Consultation Response from: KC Environmental Health (Pollution & Noise Control)
2023/91344 - Land adj, 21, Thomas Street, Lindley, Huddersfield, HD3 3JJ
Outline application for erection of care home (Use Class C2) of up to 60 beds with associated access and sub station
Date Responded:
28th June 2023
Responding Officer:
NH
Responding Ref:
WK/202318436

Drawing Title
Proposed Site Plan

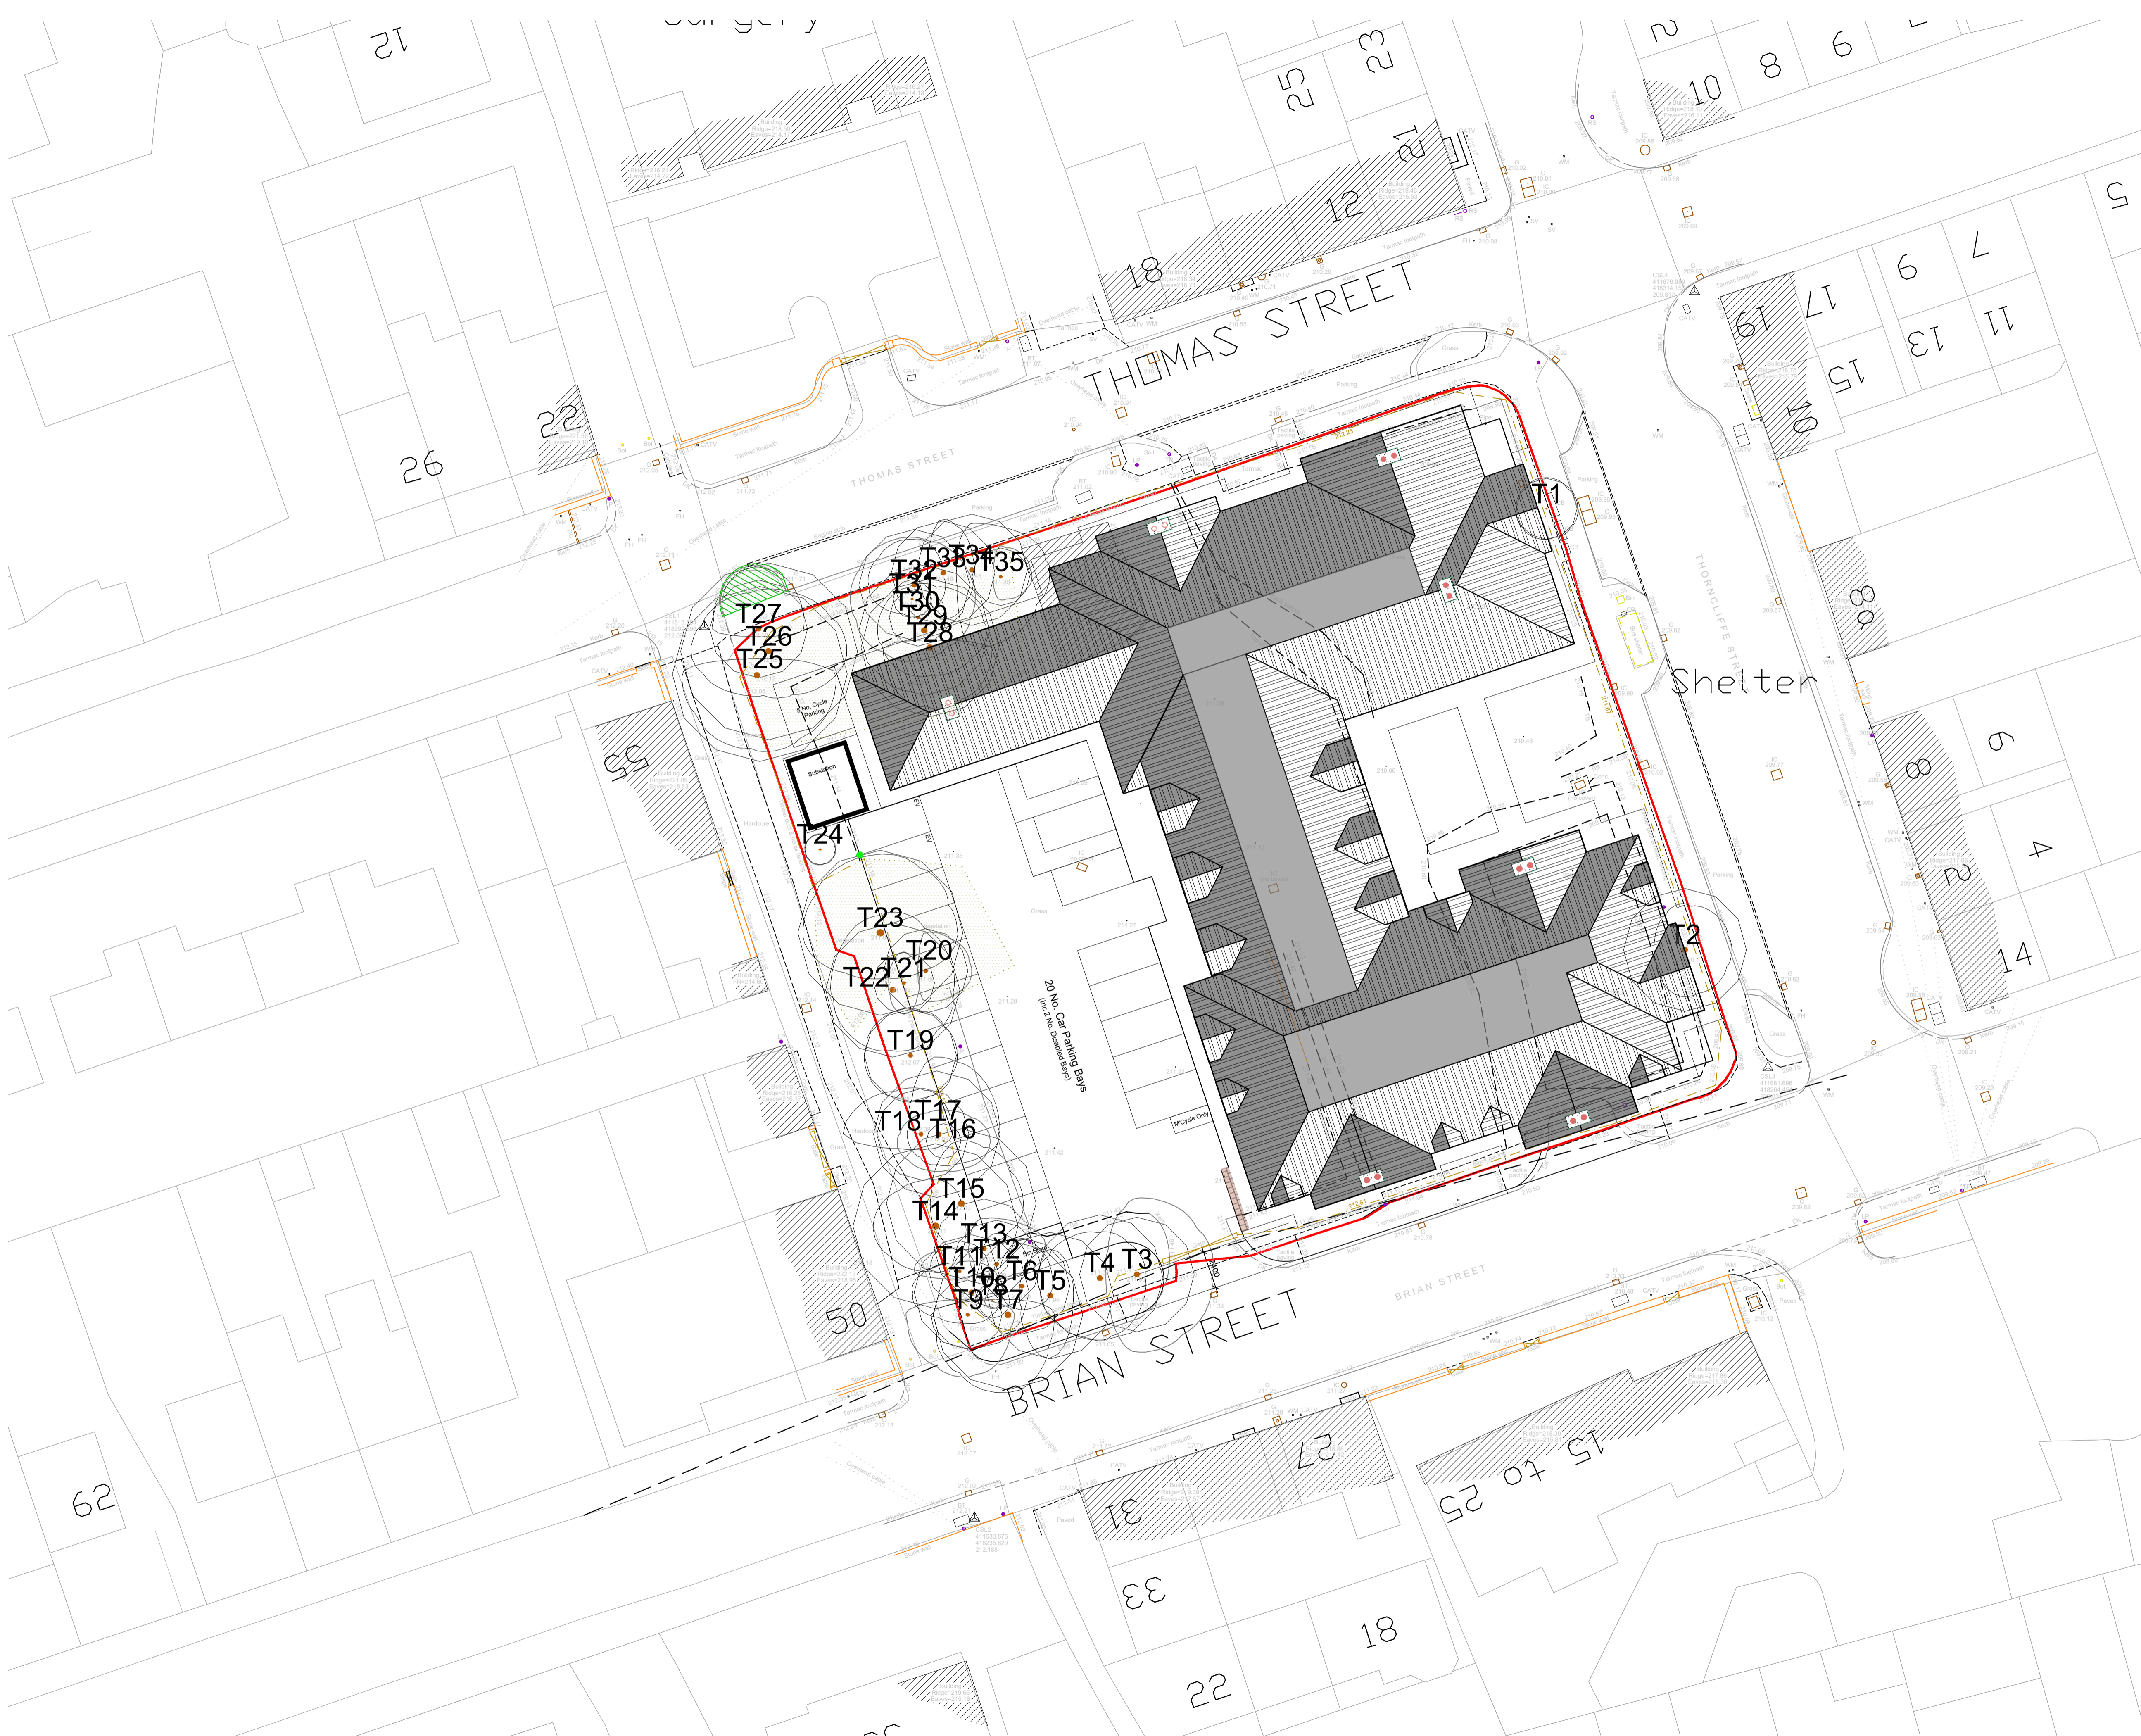
On-site parking is proposed. Electric vehicle charging provision is detailed in the Proposed Site Plan by ADG Architects (ref: H.21.81) In an application of this nature, it is expected that facilities for charging electric vehicles and other ultra-low emission vehicles are provided in accordance with the National Planning Policy Framework and *Air Quality & Emissions Technical Planning Guidance* from the West Yorkshire Low Emissions Strategy Group. As such, a condition requiring charging points is therefore necessary.

Before first occupation, a scheme detailing the dedicated facilities that will be provided at the premise for charging electric vehicles and other ultra-low emission vehicles shall be submitted to and approved in writing by the Local Planning Authority. The scheme shall meet the requirements of the current West Yorkshire Low Emission Strategy (WYLES) document. The approved dedicated facilities for charging electric vehicles shall be installed prior to occupation and retained for use thereafter.
